CITY OF ALBUQUERQUE

Re: Burger King
3221 Coors Blvd. NW
30-Day Temporary Certificate of Occupancy
Transportation Development Final Inspection
Architect's Stamp dated 04-10-24 (G11-D003D)
Certification dated 09-18-24

## TRAFFIC CIRCULATION LAYOUT

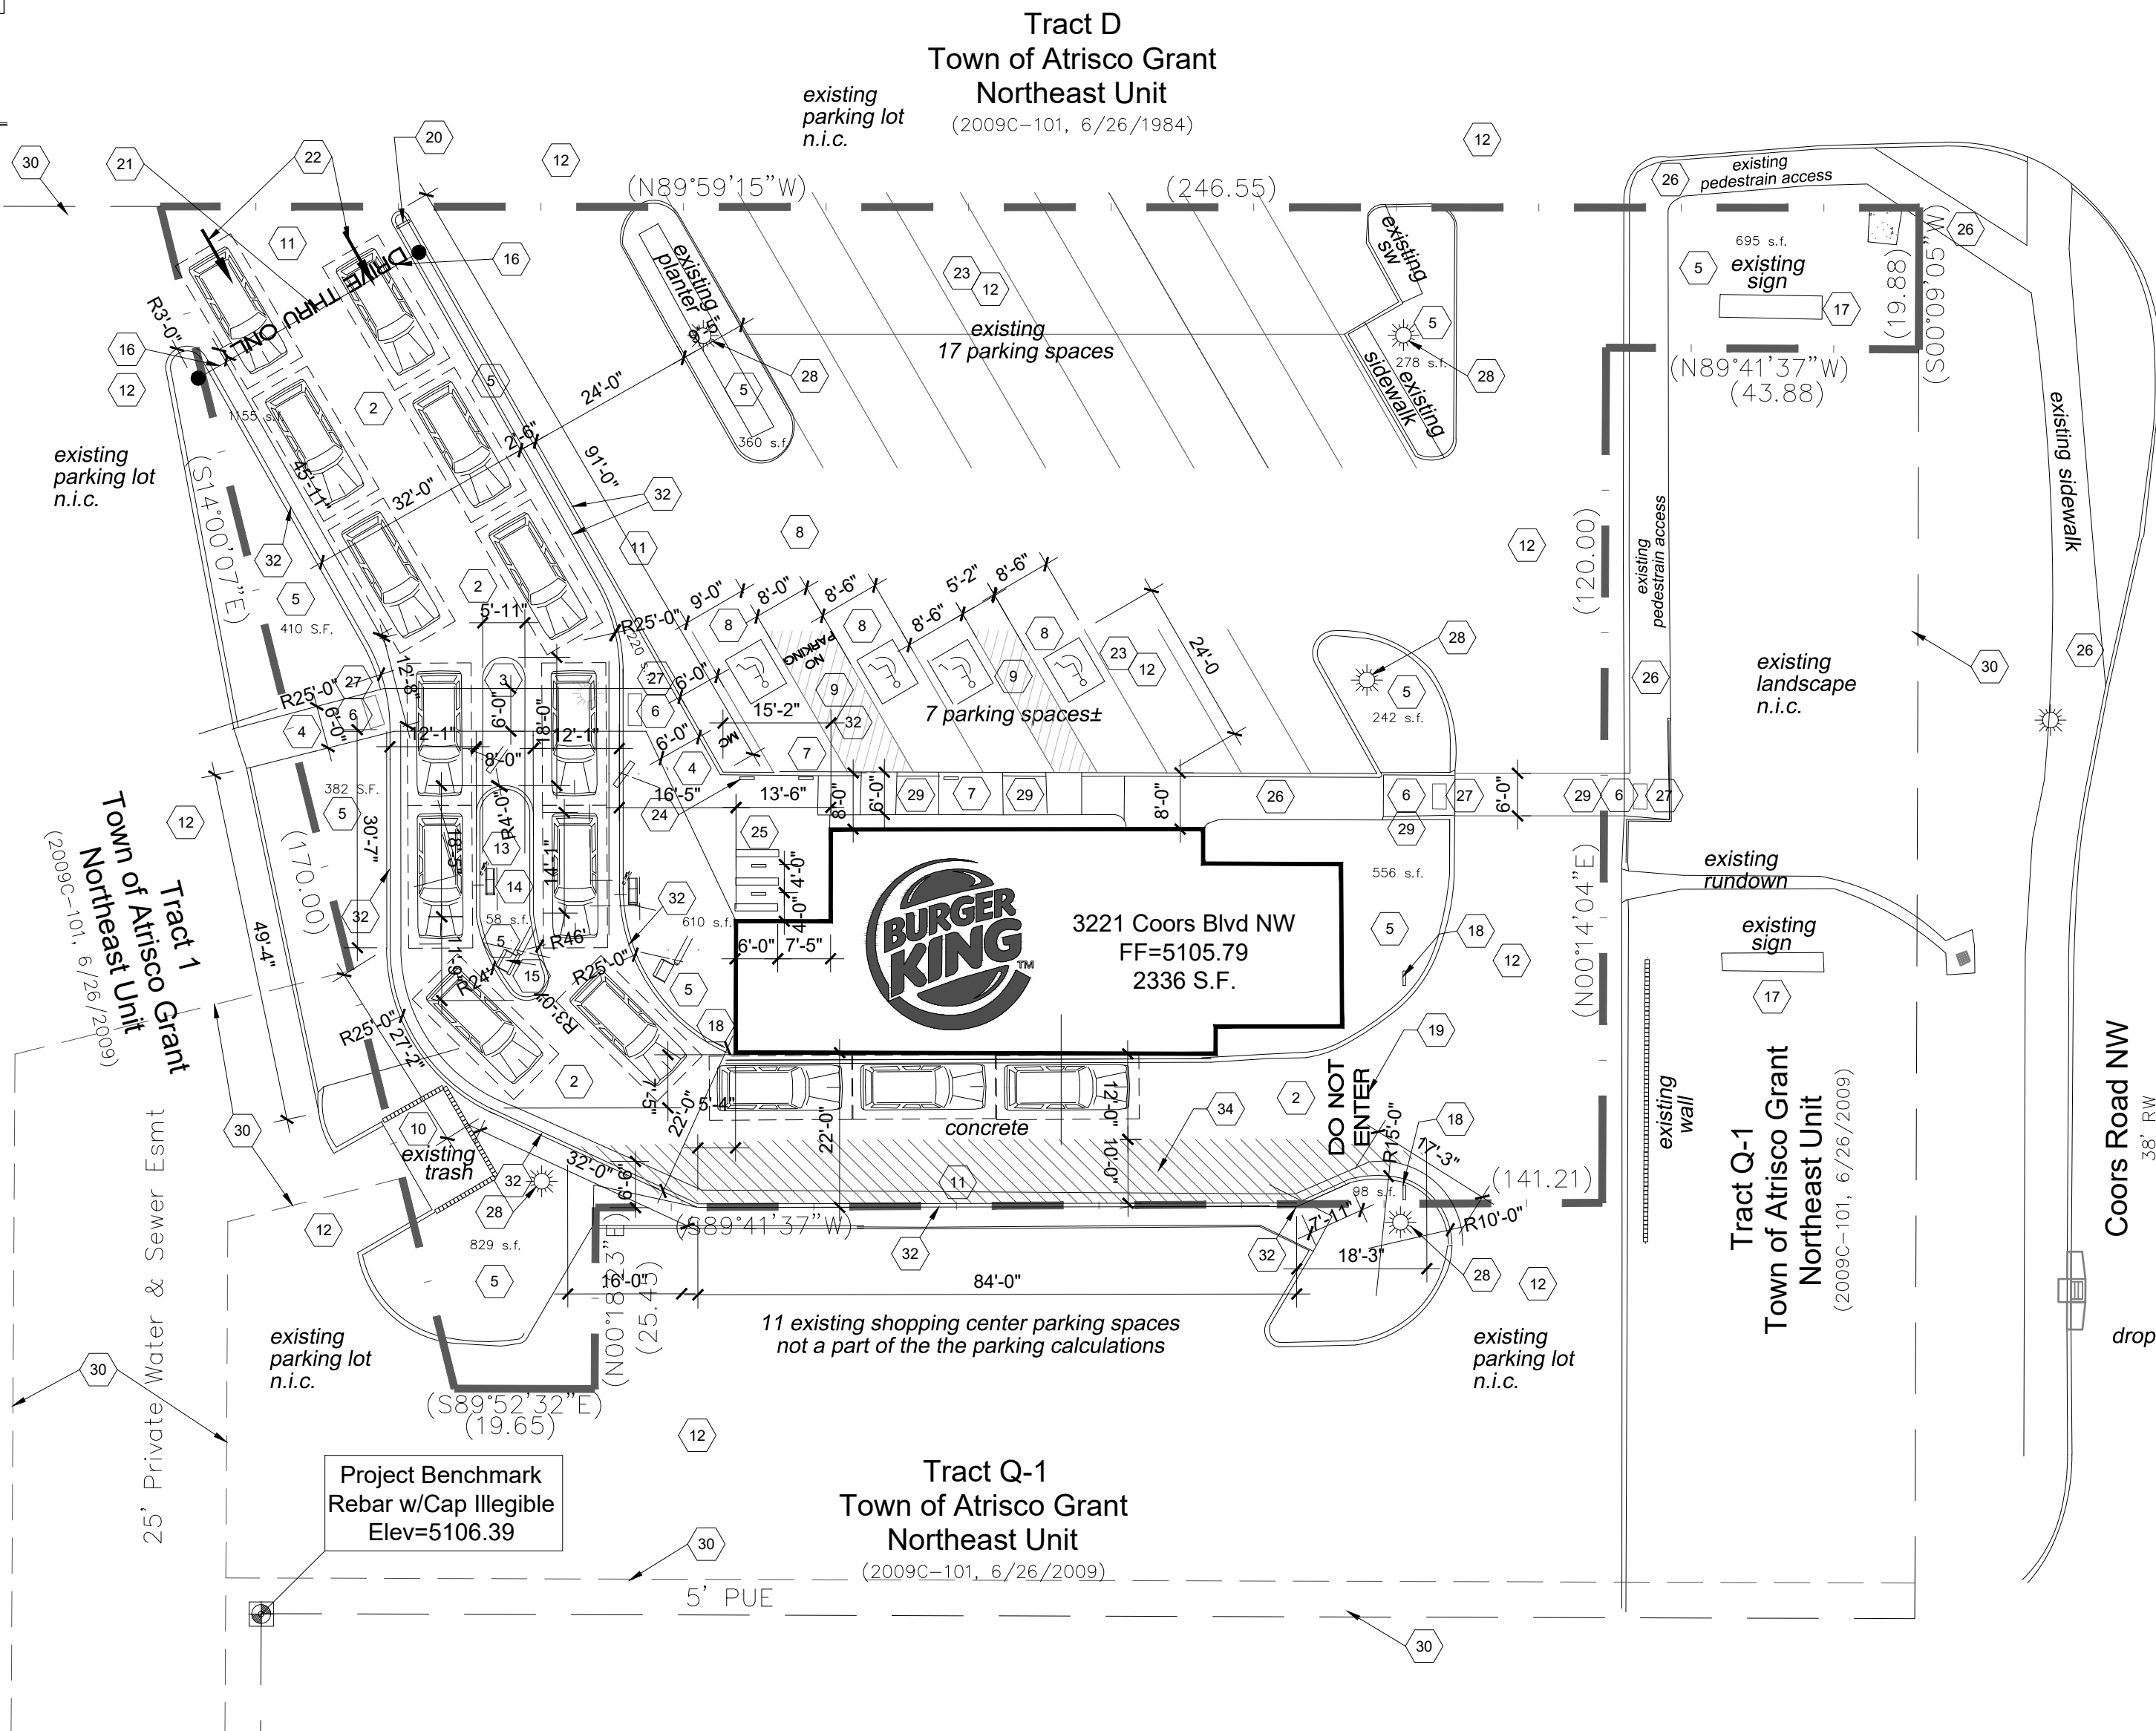
- The ADA access aisles shall have the words **"NO PARKING"** in capital letters, each of which shall be at least one foot high and at least two inches wide, placed at the rear of the parking space so as to be close to where an adjacent vehicle's rear tire would be placed. (66-1-4.1.B NMSA 1978)

- Per city requirements, Bicycle racks shall be sturdy and anchored to a concrete pad.
- Keynote 29: the existing ramps do not meet ADA standard. Based on the site visit, the running slope of the existing ramps ranged between 8.5% to 10%, while ADA requirements specify the running slope should not exceed 8.3%. The existing ramp should be upgrade to meet the current ADA standard.
